Item No. **Report of the Head of Planning, Sport and Green Spaces**

Address 11 WALNUT WAY RUISLIP

Development: Raising of roof to create first floor, single storey rear extension, single storey front extension and conversion of garage to habitable use involving demolition of porch and alterations to fenestration to all elevations

LBH Ref Nos: **10279/APP/2015/3193**

Date 18.06.2015	Scale 1:200 / A3
PROPOSED DWELLING HOUSE AT No. 11 WALNUT WAY RUISLIP MIDDLESEX HA4 6TA				SITE PLANS	
				DRAWING No. 11/104

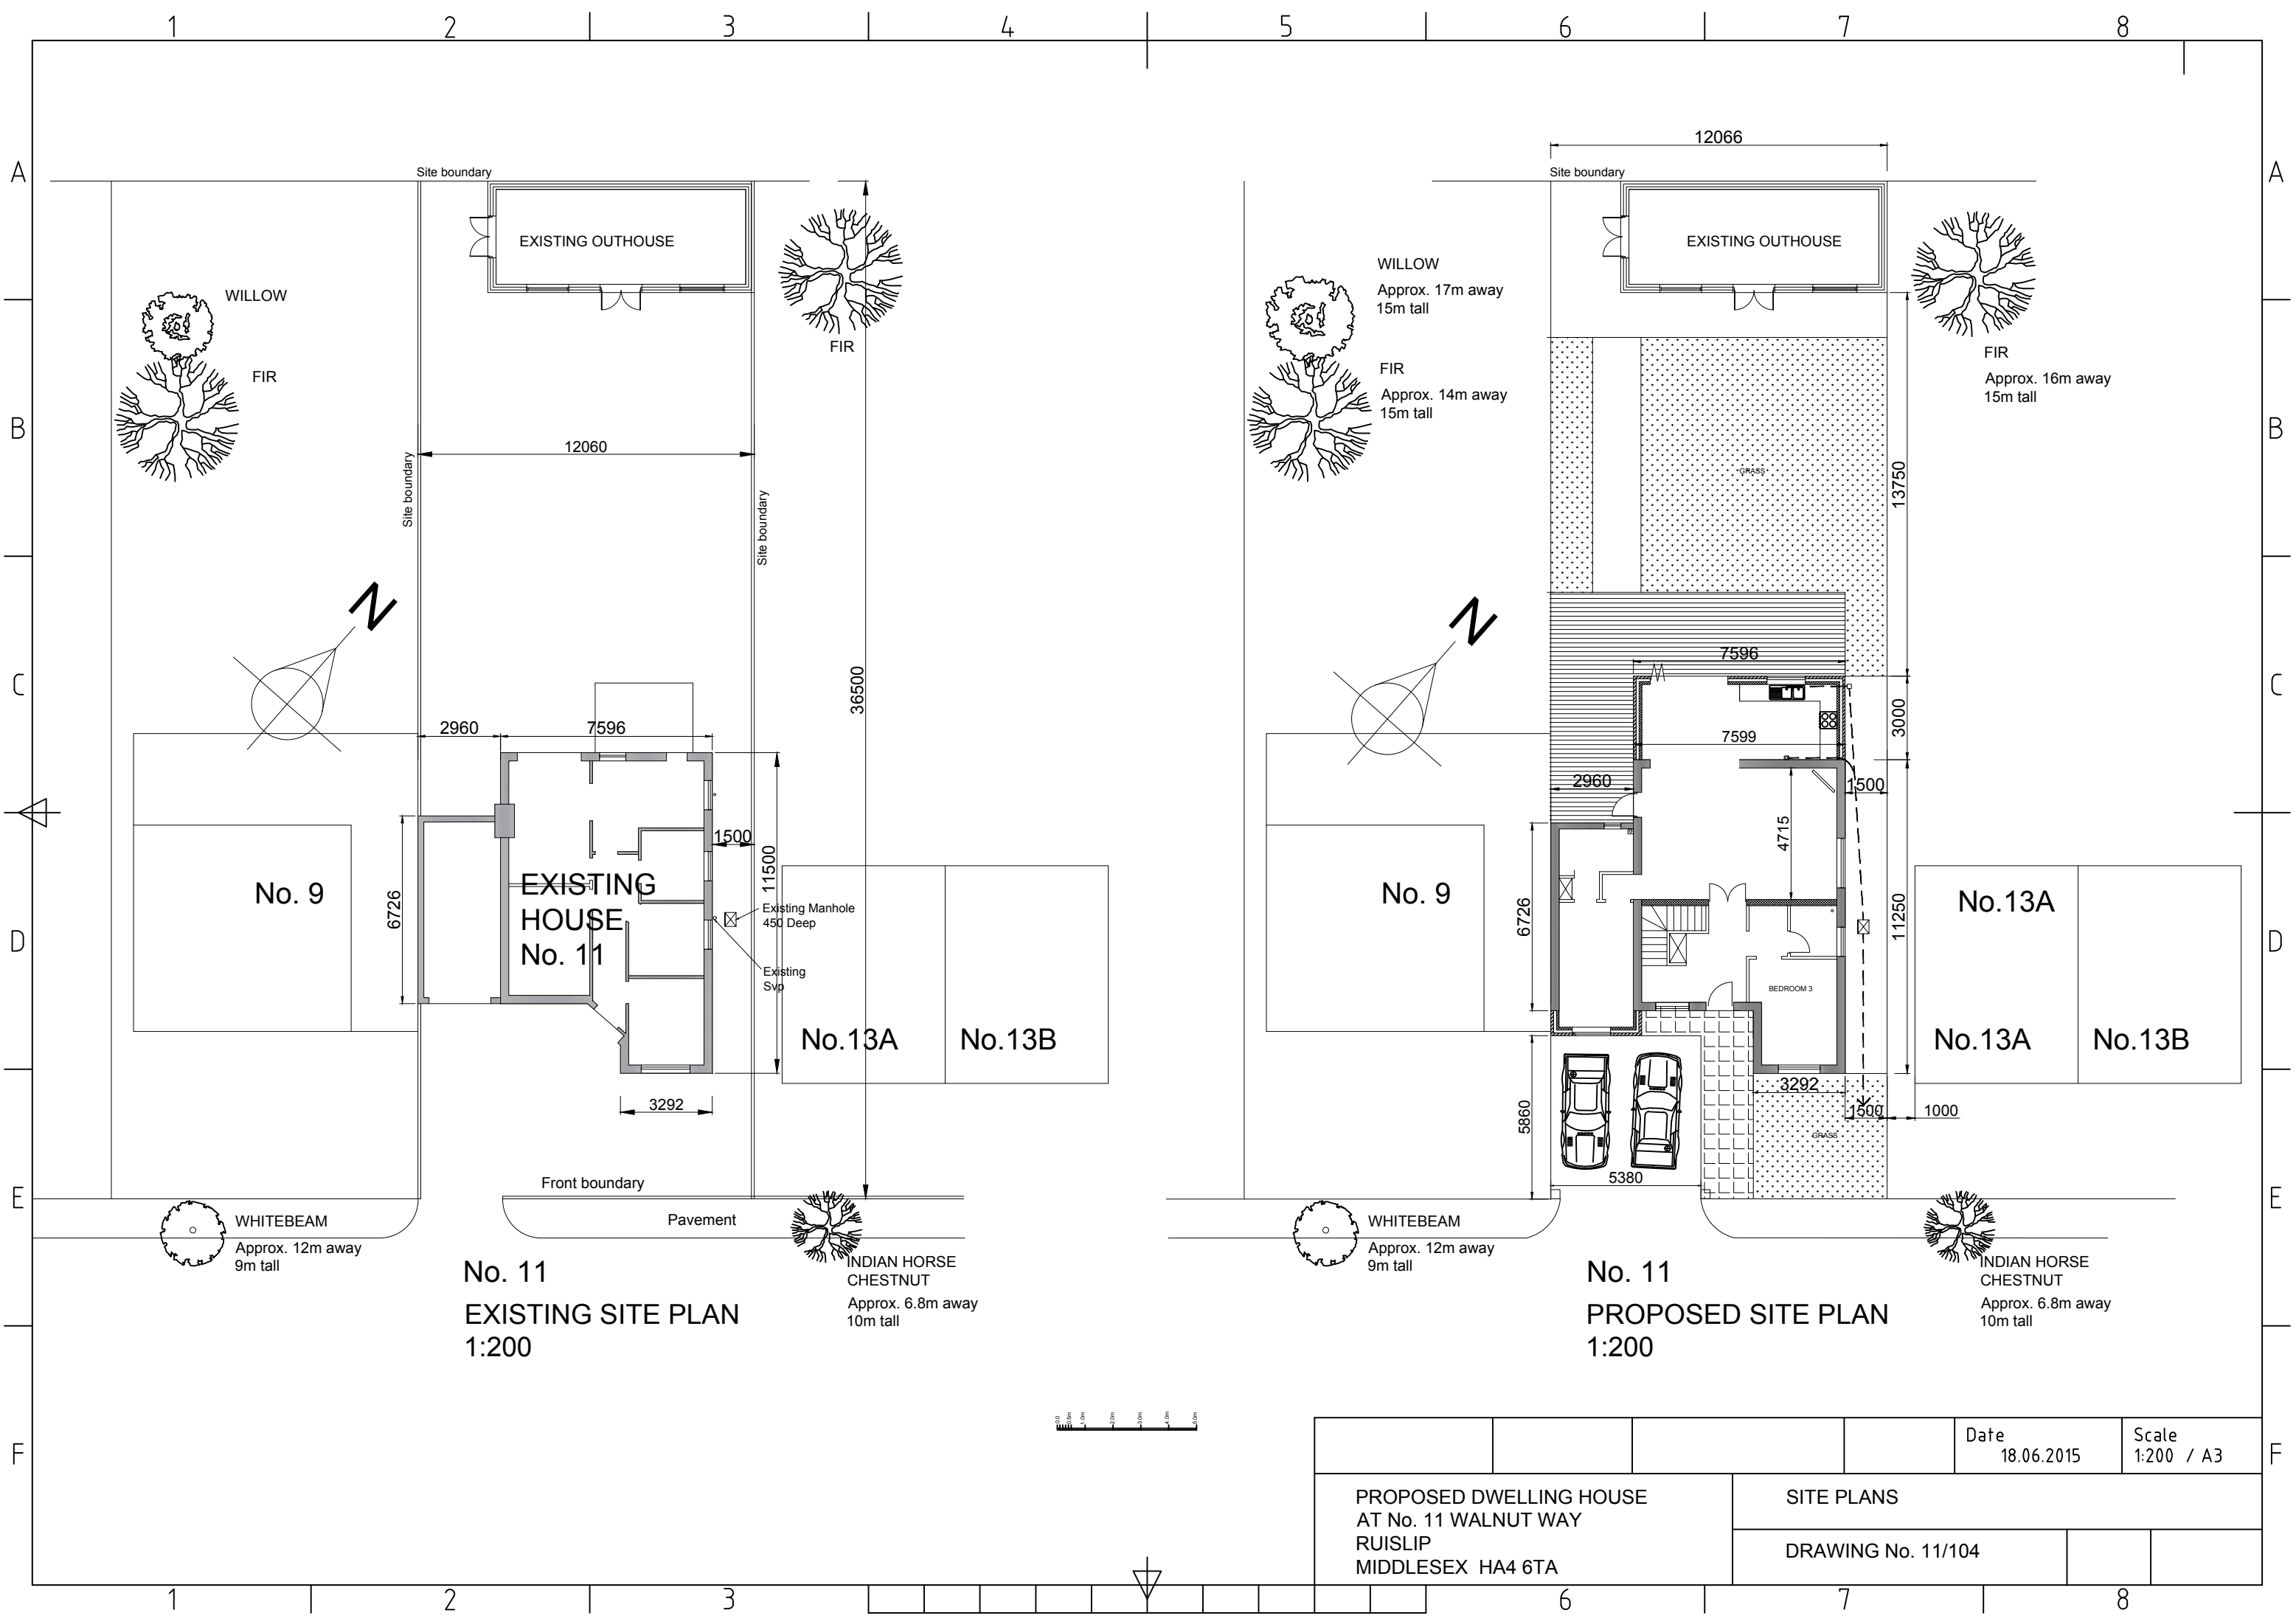
The footprint of the existing building projects 2m beyond the rear wall of no13 Walnut Drive. Therefore the additional 3m extension the full extent to which the ground floor of the property would extend is 5m. No.13 Walnut Way is converted to flats and the main window provide natural light to the lounge area of the ground floor flat are located within the rear elevation close to the shared boundary with no.11 Walnut Way. It is likely that there would be a reduction in the amount of natural light entering this window as a result of the ground floor extension, particularly as the proposed extension will breach the 45 line of sight taken from the centre of this window, which is contrary to with paragraph 4.12 of HDAS:Layout and Policy BE20 of the Hillingdon Local Plan: Part Two - Saved UDP Policies (November 2012) and the adopted Supplementary Planning Document HDAS: Residential Layout.

Policy BE21 seek to ensure no loss of residential amenity due to bulk and mass and siting. The rear garden area to no.13 Walnut Way is divided between the two flatted properties with the plot nearest to the dwellinghouse is allocated to the ground floor property. Given that the footprint of the existing building projects 2m beyond the rear wall of no13 Walnut Drive and the additional 3m extension means the full extent to which the ground floor of the property would extend is 5m. This is a significant mass and bulk which would create an undue sense of enclosure and be an overbearing presence, particularly acute when the occupants are using the rear garden.

The proposed single storey rear element, by virtue of its size, scale, depth and proximity, would be detrimental to the amenities of the adjoining occupier at 13 Walnut Way by reason of overdominance, overshadowing, visual intrusion, loss of light and loss of outlook. Therefore the proposal would be contrary to Policies BE19, BE20 and BE21 of the Hillingdon Local Plan: Part Two - Saved UDP Policies (November 2012) and the Council's adopted Supplementary Planning Document HDAS: Residential Extensions
